From: Amanda Scholes on behalf of Planning.Responses
Sent: 10 April 2018 10:15
To: Planning Scanning
Subject: FW: Tudor Lodge, Sea Road, Condition 3 [EP/24/18/DOC]

From: Katie Kurek [<mailto:katie.kurek@westsussex.gov.uk>]
Sent: 03 April 2018 12:24
To: Anita Gardner
Subject: RE: Tudor Lodge, Sea Road, Condition 3 [EP/24/18/DOC]

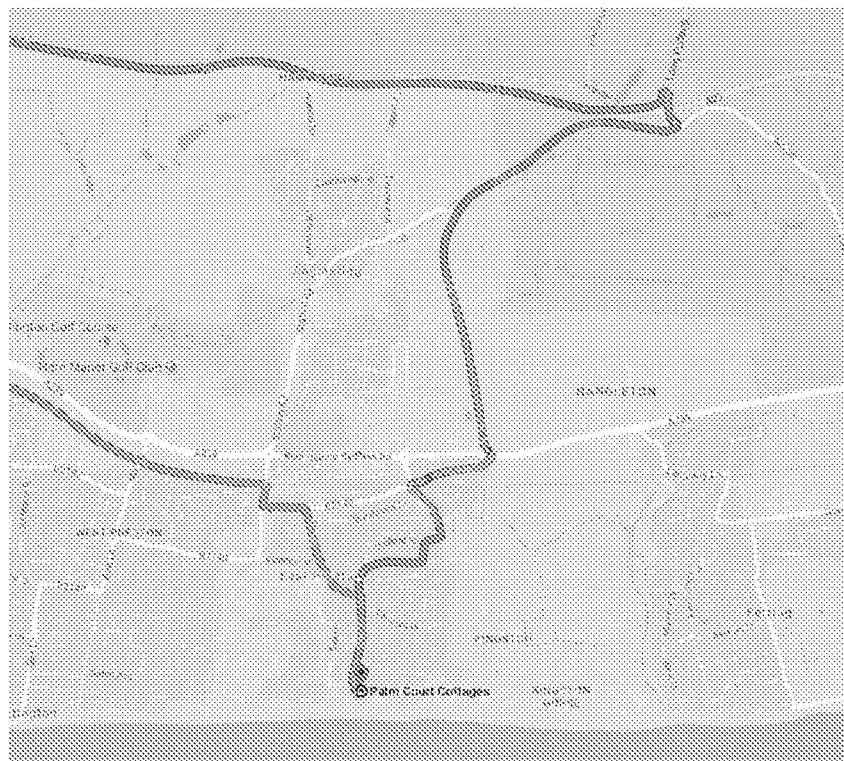
Thank you for this additional information. I see that the CMP has now been provided in colour allowing me to identify the areas for wheel washing at the entrance. Areas for material/ plant storage, loading/unloading and the area for limited contractor parking within the site have not been identified. The LHA acknowledge the restraints of the site and consider that such areas will vary within the site during construction. The applicant is reminded that skips/ materials etc. should not be placed in the public highway and that if a skip was to be placed in the highway the appropriate licence would need to be obtained prior to this.

The plans and details pertaining to the condition are acceptable from a highway safety and capacity point of view.
